RE: Sea Link (EN020026) Nationally Significant Infrastructure Project (NSIP) Application – Written Representations Summary (Deadline 3A – Change Request) – Kent Wildlife Trust (F0B50218B)

This Summary accompanies Kent Wildlife Trust’s (“KWT”) Written Representations submitted at Deadline 3A in response to the Applicant’s Change Request relating to Change 1 – Access at the Hoverport, Kent. It sets out the key issues raised and highlights the fundamental concerns that, in KWT’s view, prevent the Change Request from being accepted in its current form. KWT’s objections raised at Deadline 1 (18th November 2025) remain fully applicable. The Change Request does not resolve those concerns and introduces further uncertainty and risk. For the reasons summarised below, KWT considers that the Change Request is premature, inadequately evidenced and cannot lawfully be accepted. This Summary should be read alongside KWT’s full Deadline 3A Written Representations.

HABITATS OF PROTECTED SPECIES AND IMPORTANT HABITATS - KENT

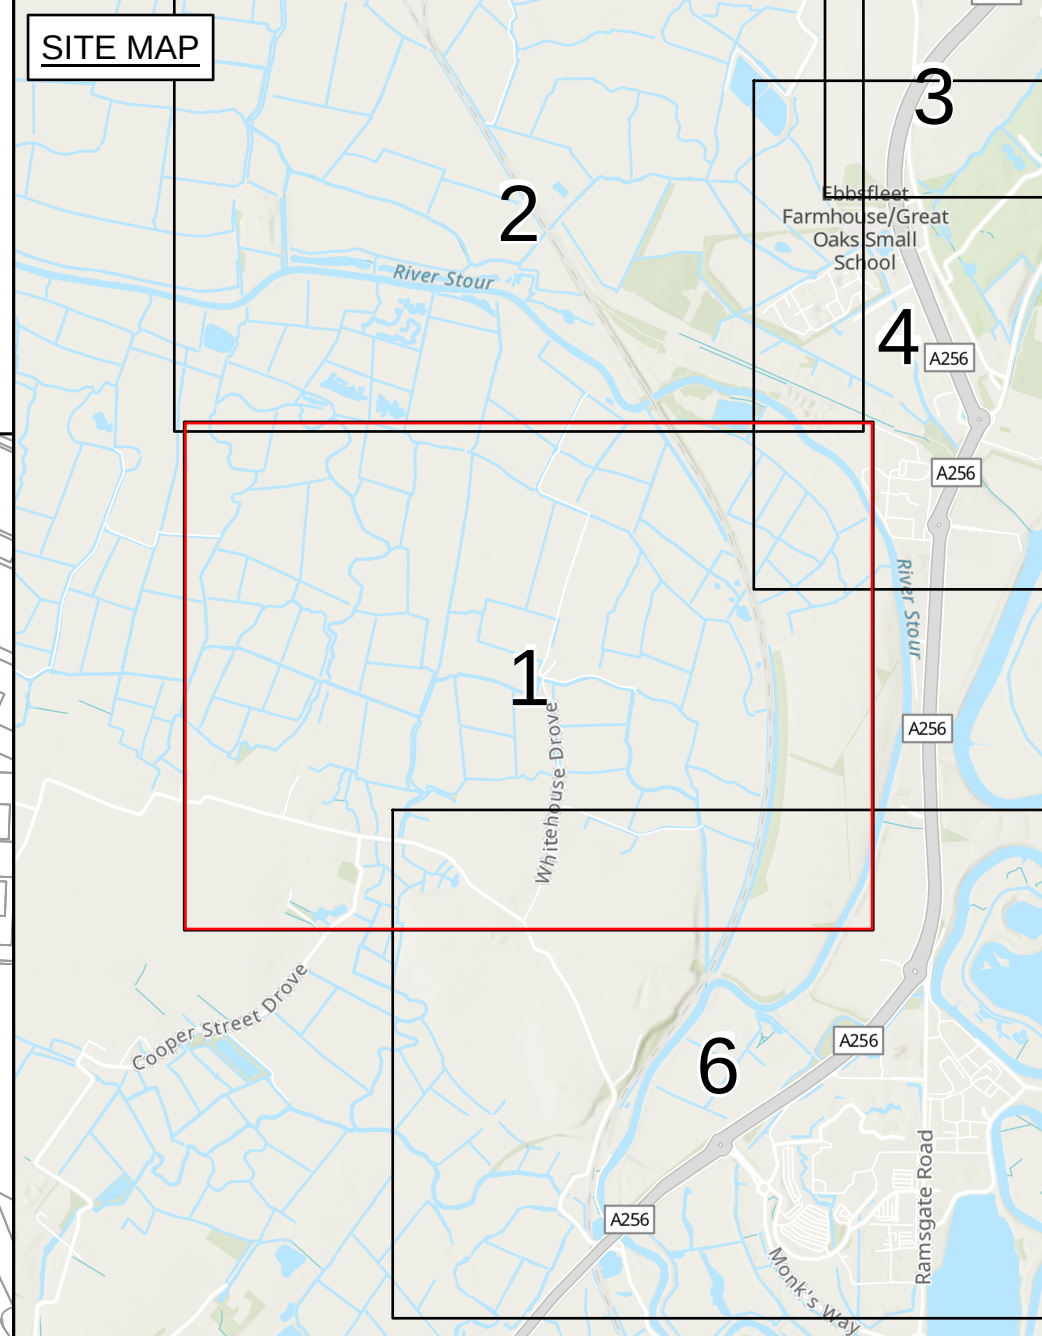
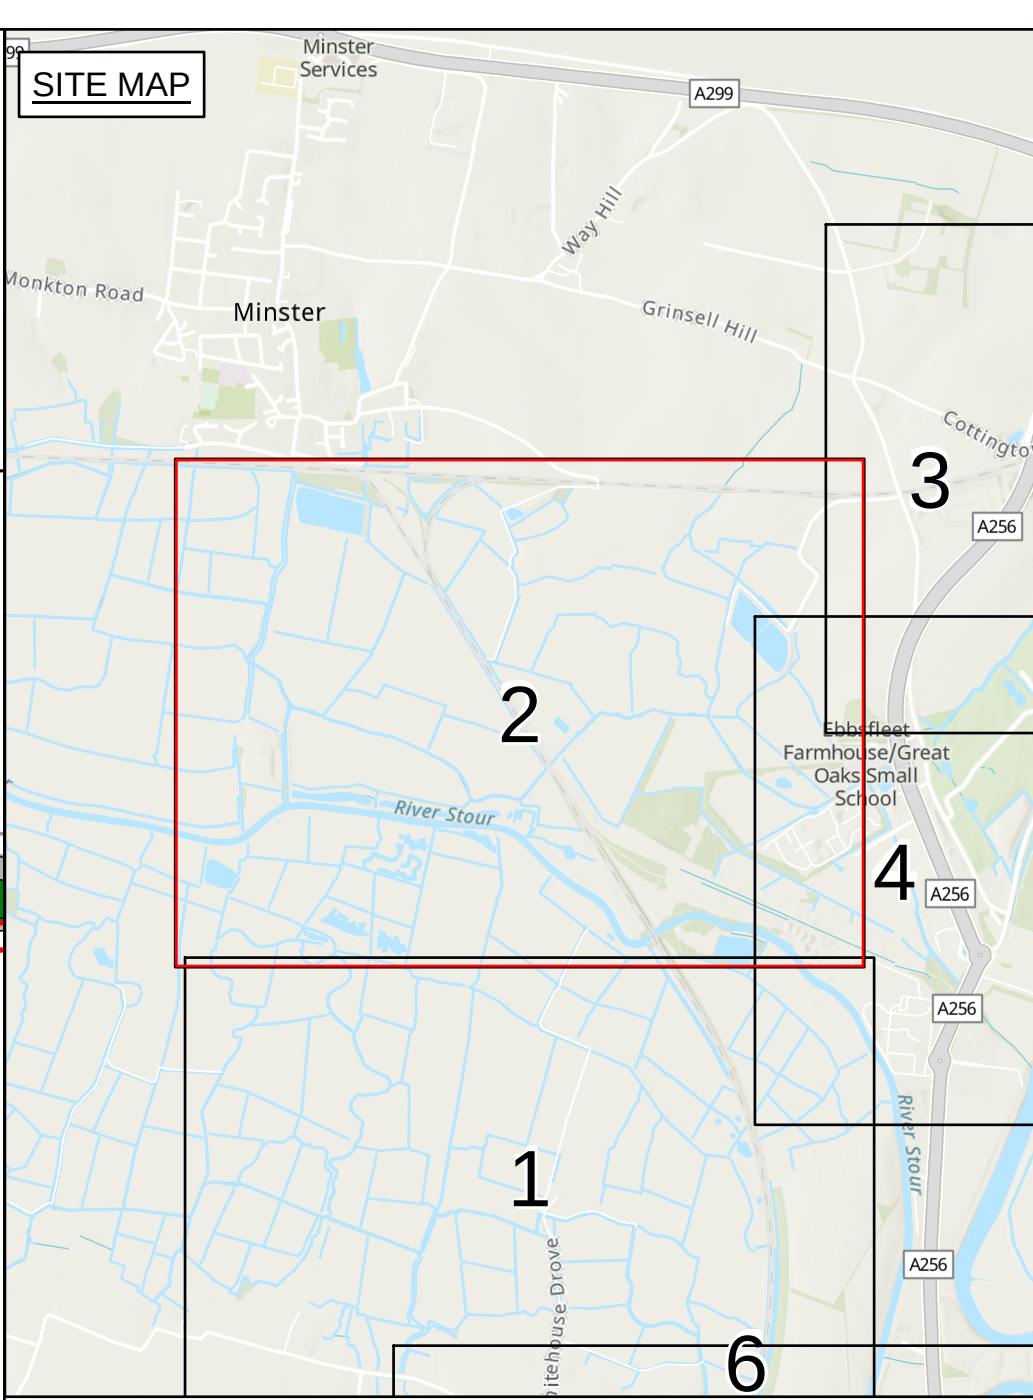
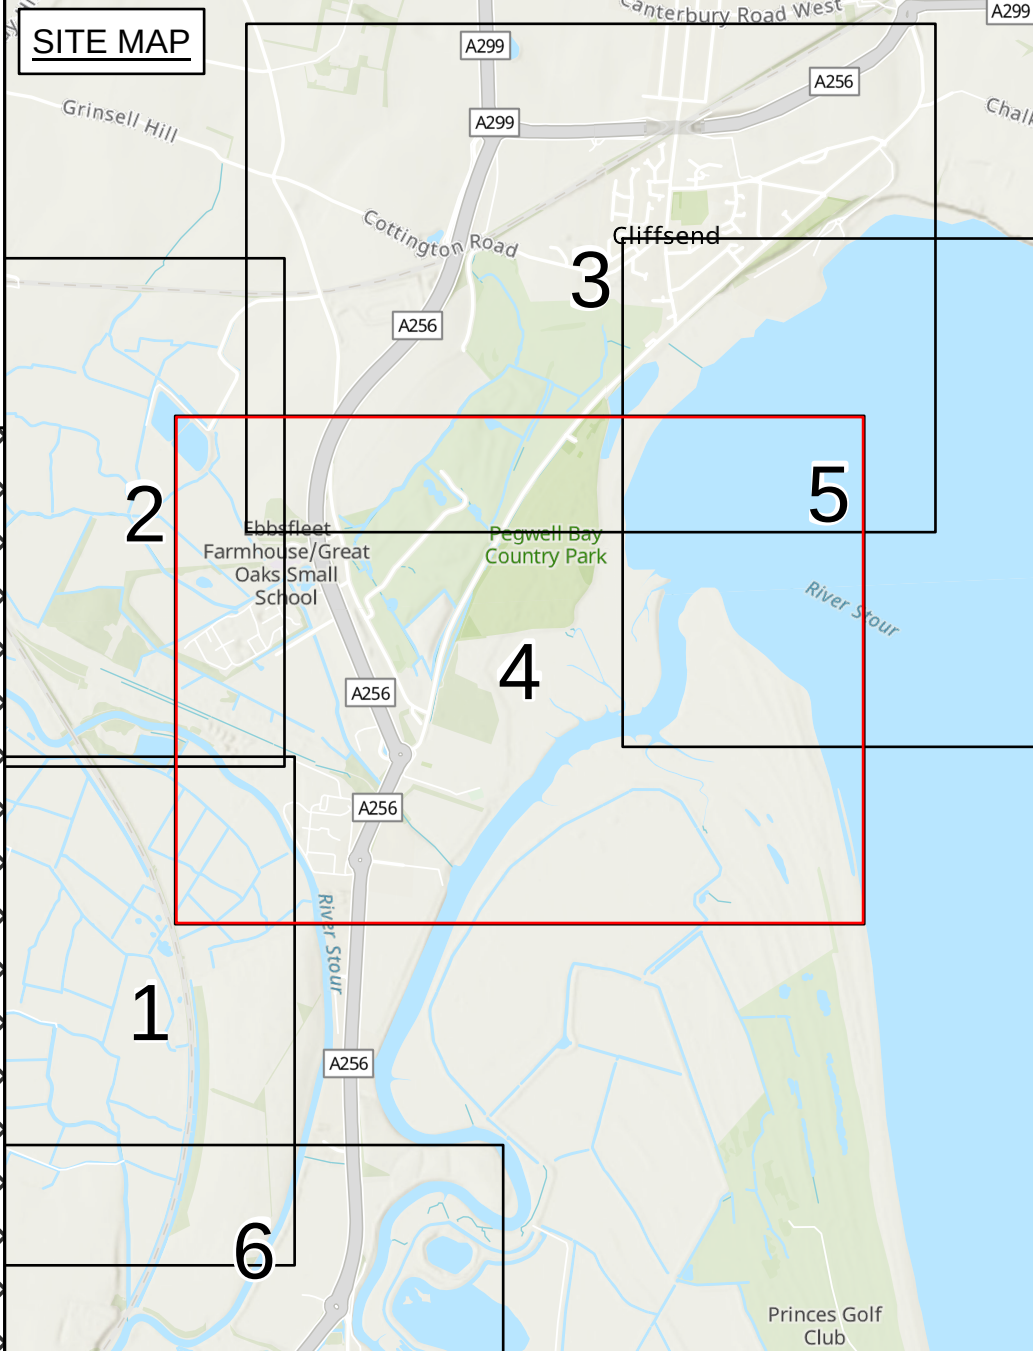
- Saltmarsh, a Section 41 Priority Habitat and qualifying feature of national and international designations, is omitted from plans suggesting to show “*Habitats of Protected Species and Important Habitats*”.
- The absence of saltmarsh mapping prevents meaningful scrutiny and undermines confidence that impacts can genuinely be avoided.
- Without accurate habitat annotation, there is no certainty that saltmarsh will not be encroached upon during construction, operation or maintenance.
- This omission represents a material deficiency in the Applicant’s environmental information.
